**Wylie Addition, Administrative Relief, ADR-17-013**

**Please accept the following comments from El Paso County Public Health regarding the project referenced above:**

SITE PLAN

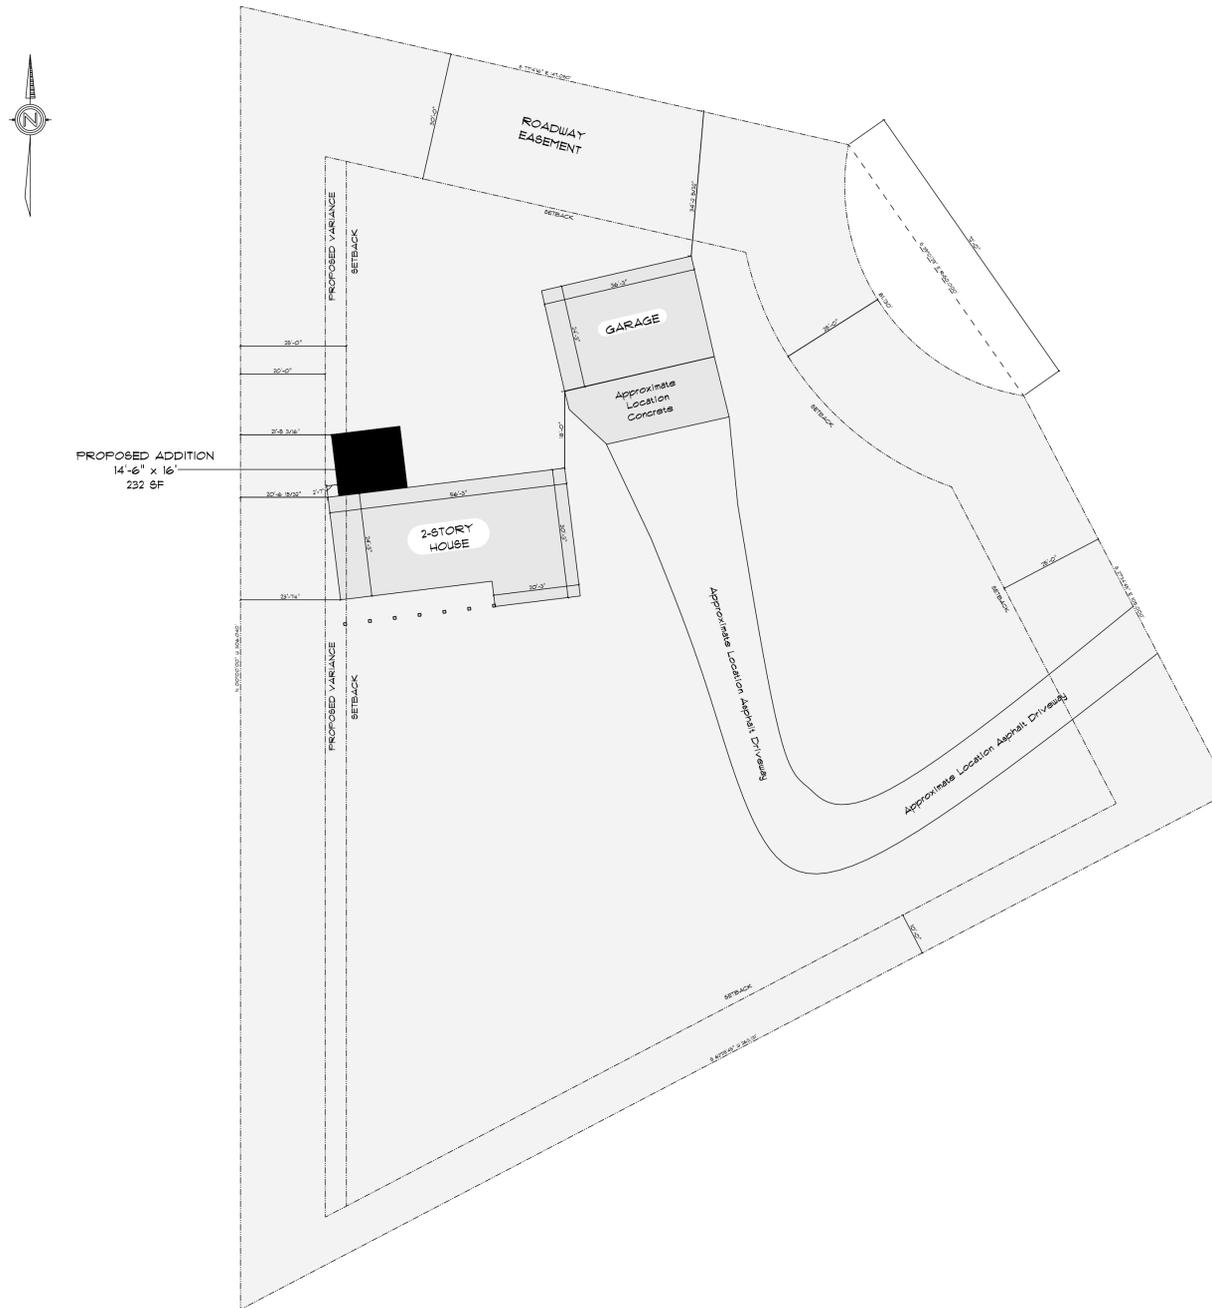
- **Although the proposed addition is on the north side of the house, please note that the on-site wastewater treatment system (OWTS) records indicate the OWTS is located on the south side of the house. Advise contractors not to drive or park in this area should your request be approved. Compaction of the soil treatment area may lead to premature system failure.**
